Application 3/2025/0363

PLANNING APPLICATION: 3/2025/0363
LAND TO THE REAR OF PENDLE STREET EAST, SABDEN, BB7 9EQ

ELEVATION

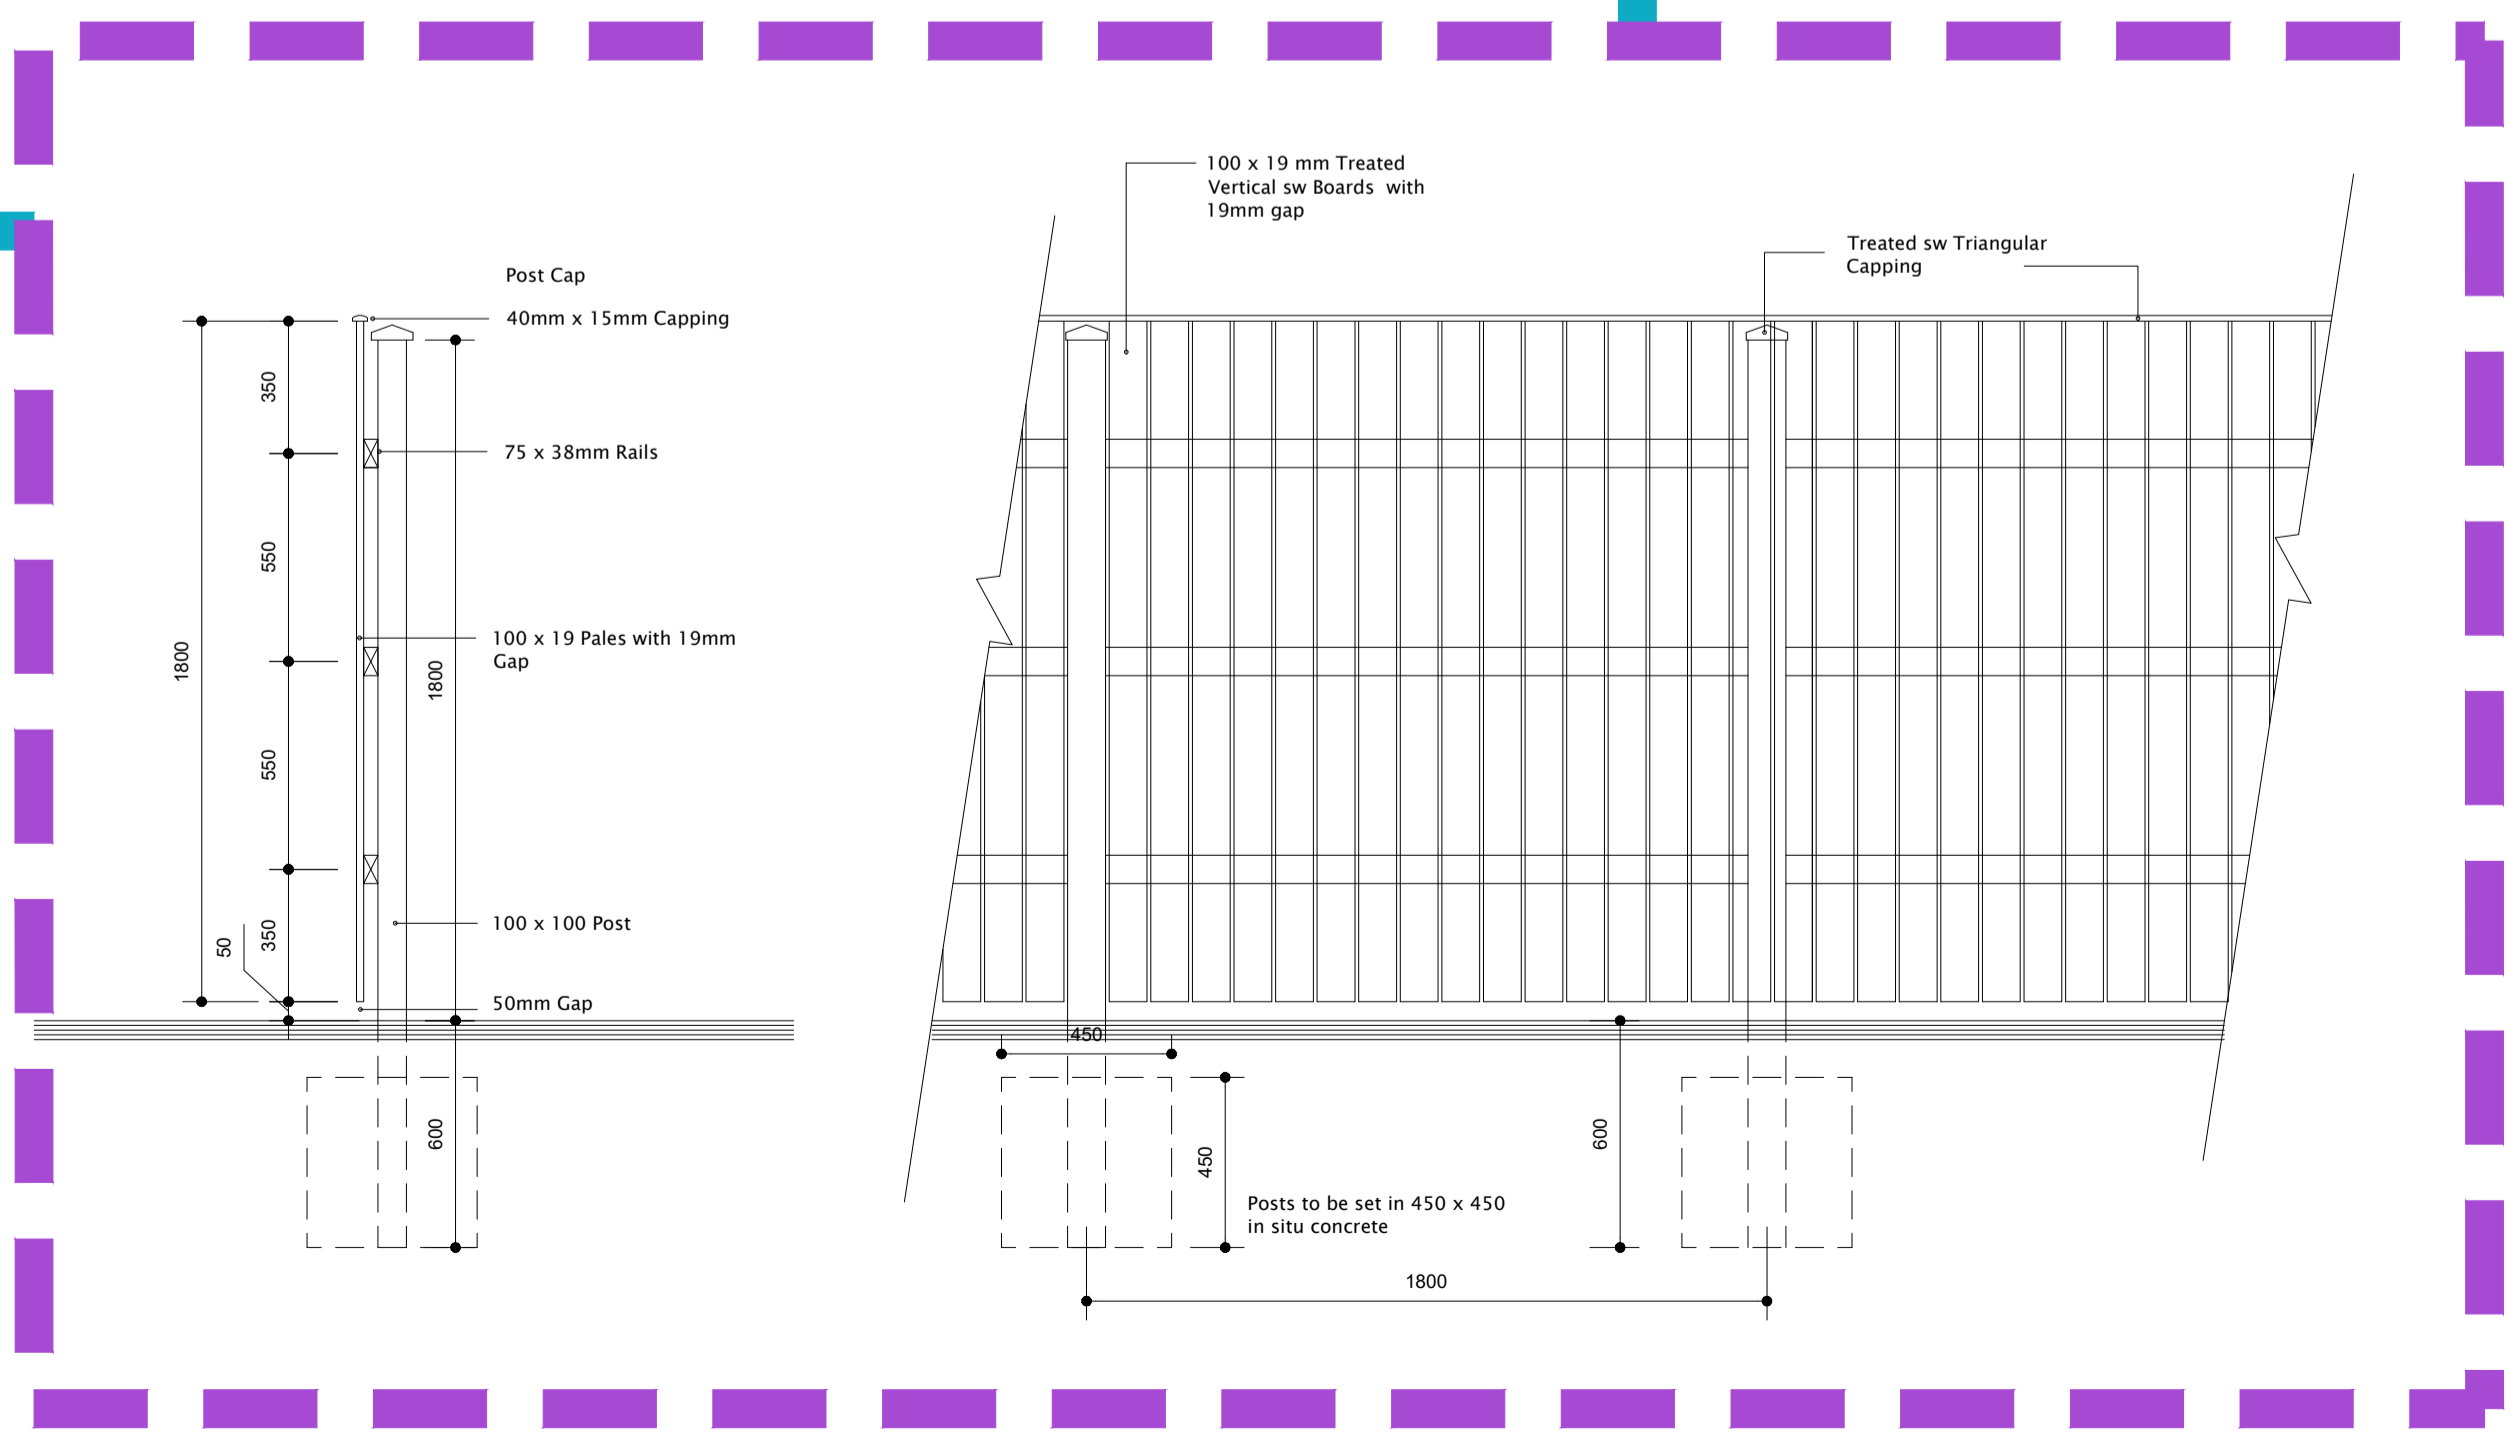
Fence around will be an eyesore and get vandalised and extremely close to football club so will cause issues. A hedge or dry stone wall would be more in keeping.

Lees Roxburgh Drg. Ref. 6757/01-03

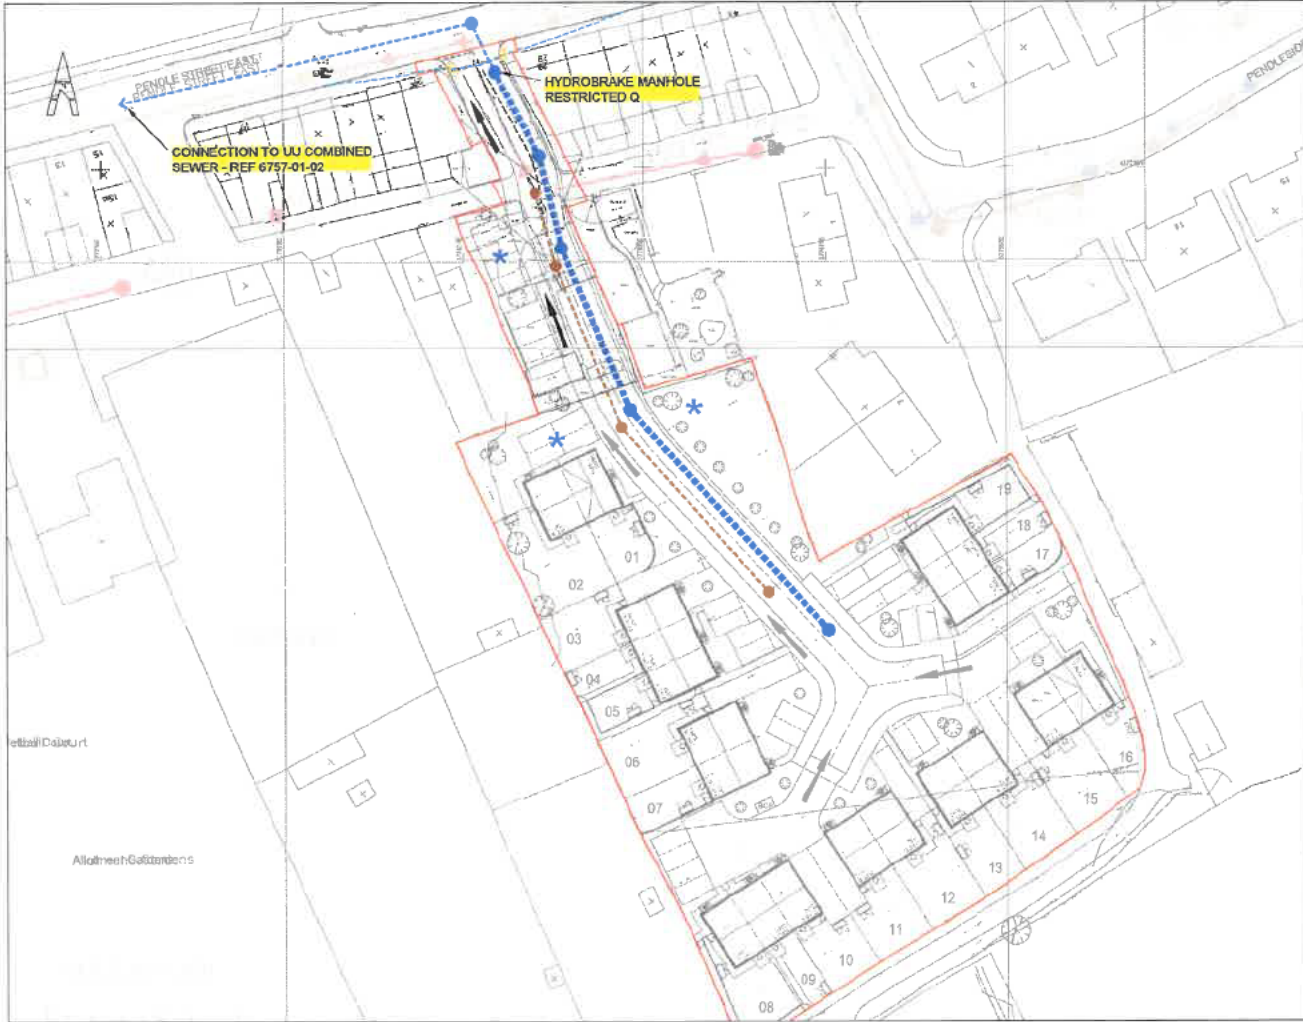
Previous and current applications confirm unsuitability for sustainable drainage and plans to

discharge into combined sewerage has previously been rejected by United Utilities for legitimate and existing reasons.

Surface drainage will also increase down the back street, and this poses both safety risk to

pedestrians, as well as flooding of back yards which are at lower elevation (houses 27 through to 11 or even further).

DRAWING NUMBER: 4668-F01	REVISION: C
------------------------------------	-----------------------

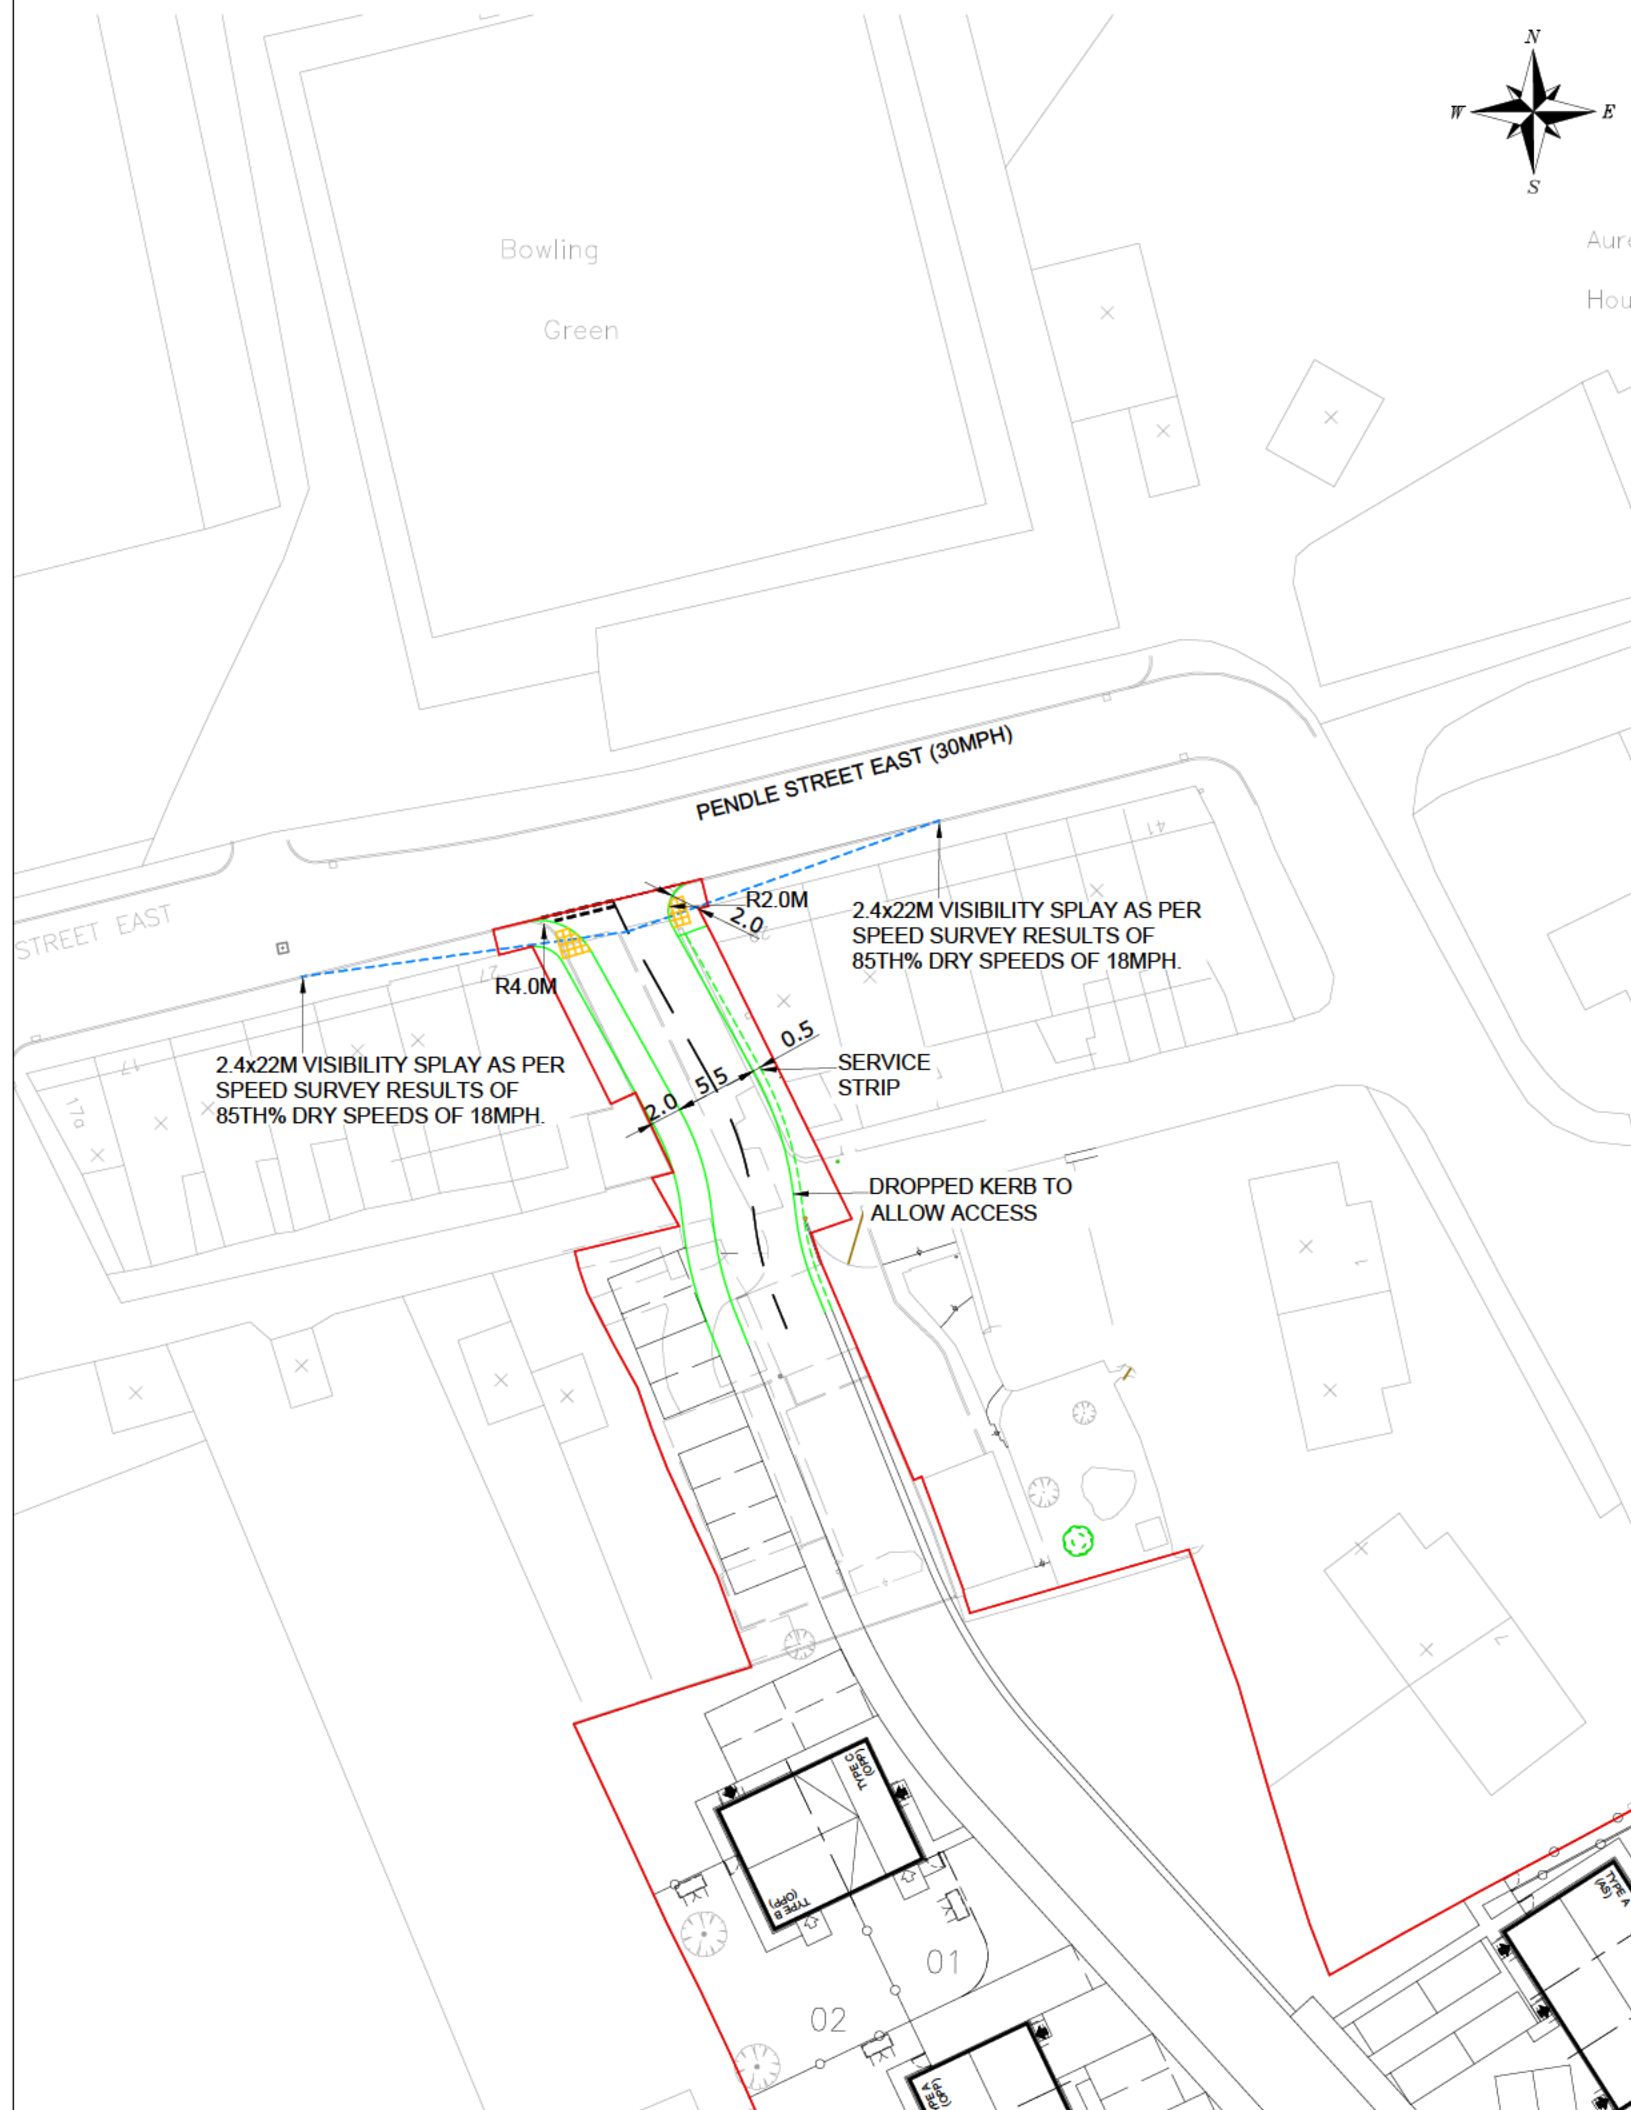
In addition, the visibility splay for the proposed junction from the new application onto Pendle Street East is inadequate for a 30mph road as it needs to be a minimum of 43 metres. The applicants state that a single traffic survey was carried out on 12th December 2024 and that the average recorded speed of vehicles was 18mph and therefore this would allow the visibility splay to be reduced. However, this survey is not a true representation of local traffic, as it was undertaken outside of the bowling season and on a day when the football pitch was not in use for training or a match. The plan provided by the applicant shows how a Lancashire refuse wagon would access the site. This would require no vehicles to be parked at the front of 23, 25, 27 and 29 Pendle Street East. As residents park their vehicles here, how would large vehicles, including plant machinery access the site? Is the intention for such vehicles to mount the grass verge and public footpath across from the proposed entrance? Or are double yellow lines being imposed? If so, where will residents of these properties park?
